RE: BP# 2017-00262_24 parsons Pond Drive

From: Gregory Gilbert [mailto:ggilbert@portlandmaine.gov]
Sent: Friday, March 17, 2017 2:19 PM
To: agagne4@maine.rr.com
Subject: BP# 2017-00262_24 parsons Pond Drive

Proposed Bedroom In Existing Finished Loft Area

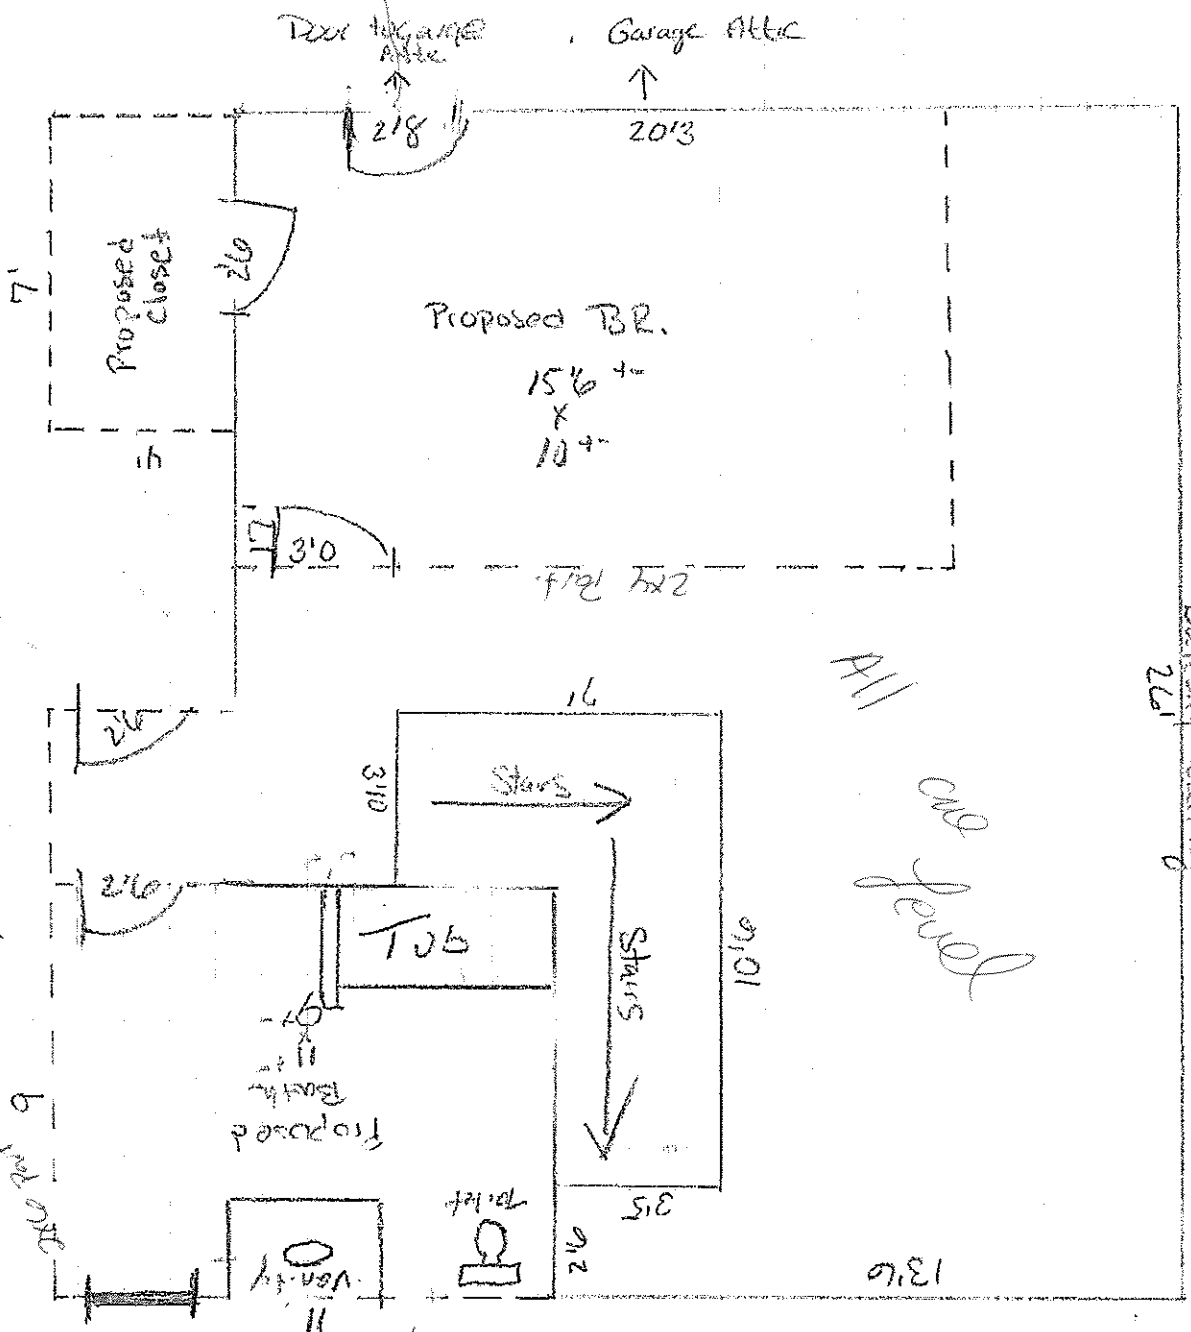
Per our conversation the other day, a bedroom will not be allowed to be added without a second means of egress that leads directly to the exterior.

please specify if the arrows on the stairs are pointing up or down

Please confirm that common walls and ceiling from the garage are fire rated.

Please specify(illustrate) the thickness of proposed walls

The area walled off in the loft space can be used as an office or some other non sleep area.

Here are the items that you have requested. I have spoken to the owner and told them that this room can not be used as a bedroom.

Marys 24 Parsons Pond
Cross Section + Notes

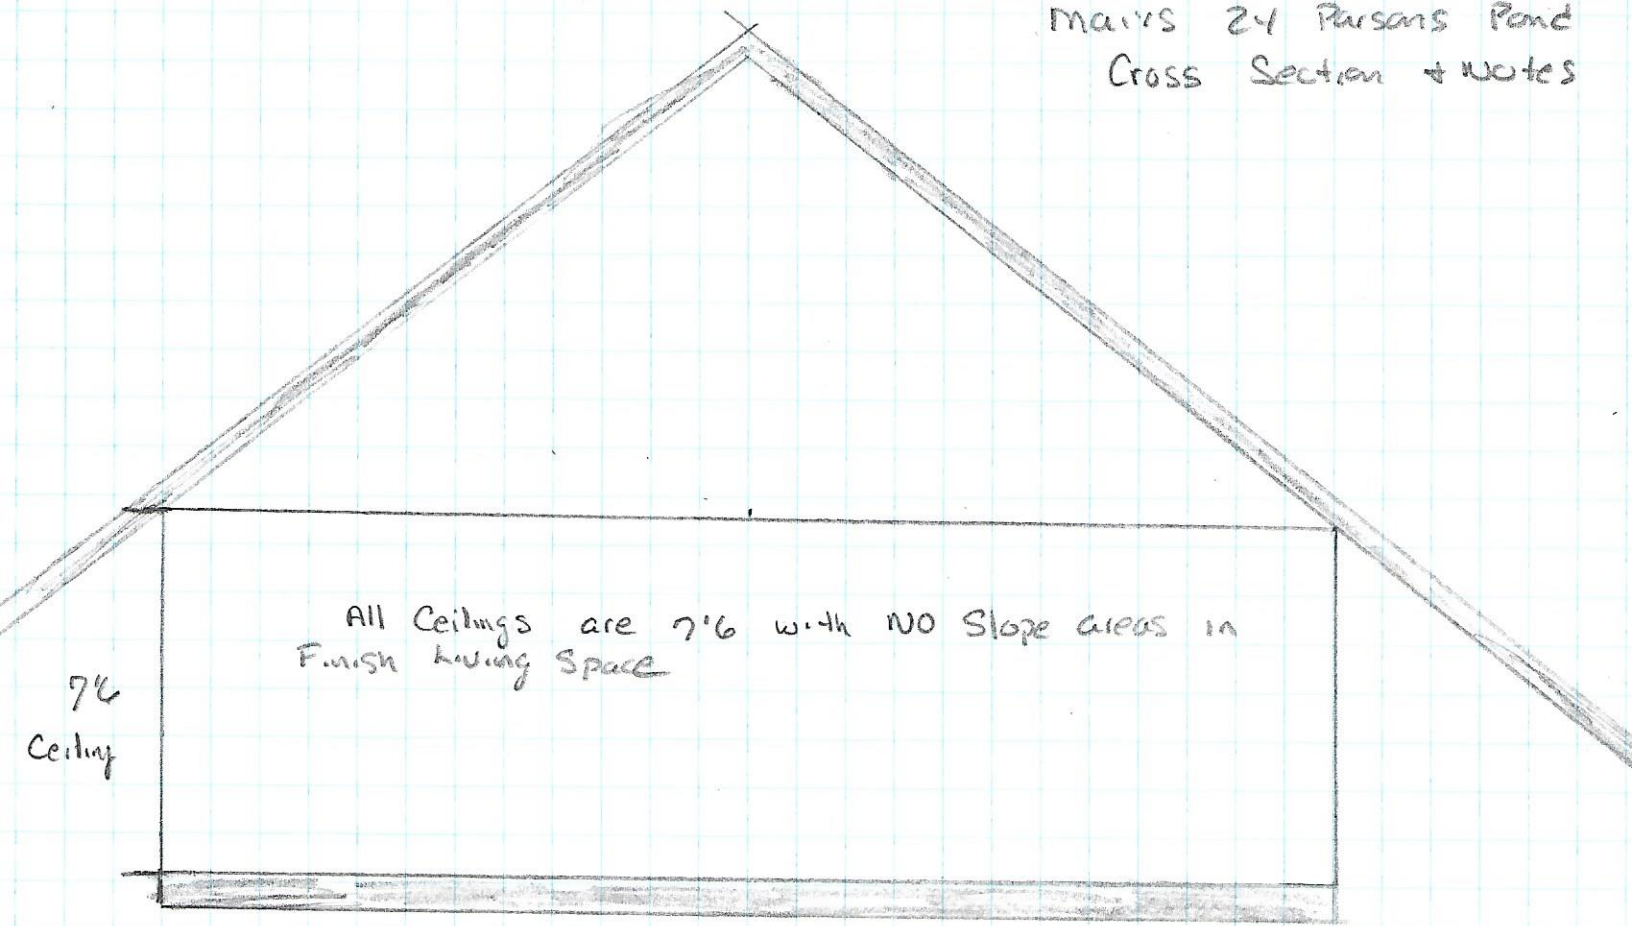
PLease provide a section of the proposed rooms illustrating, that if the ceiling is sloped, the height is at least 6'8 above fixtures at at entry points.
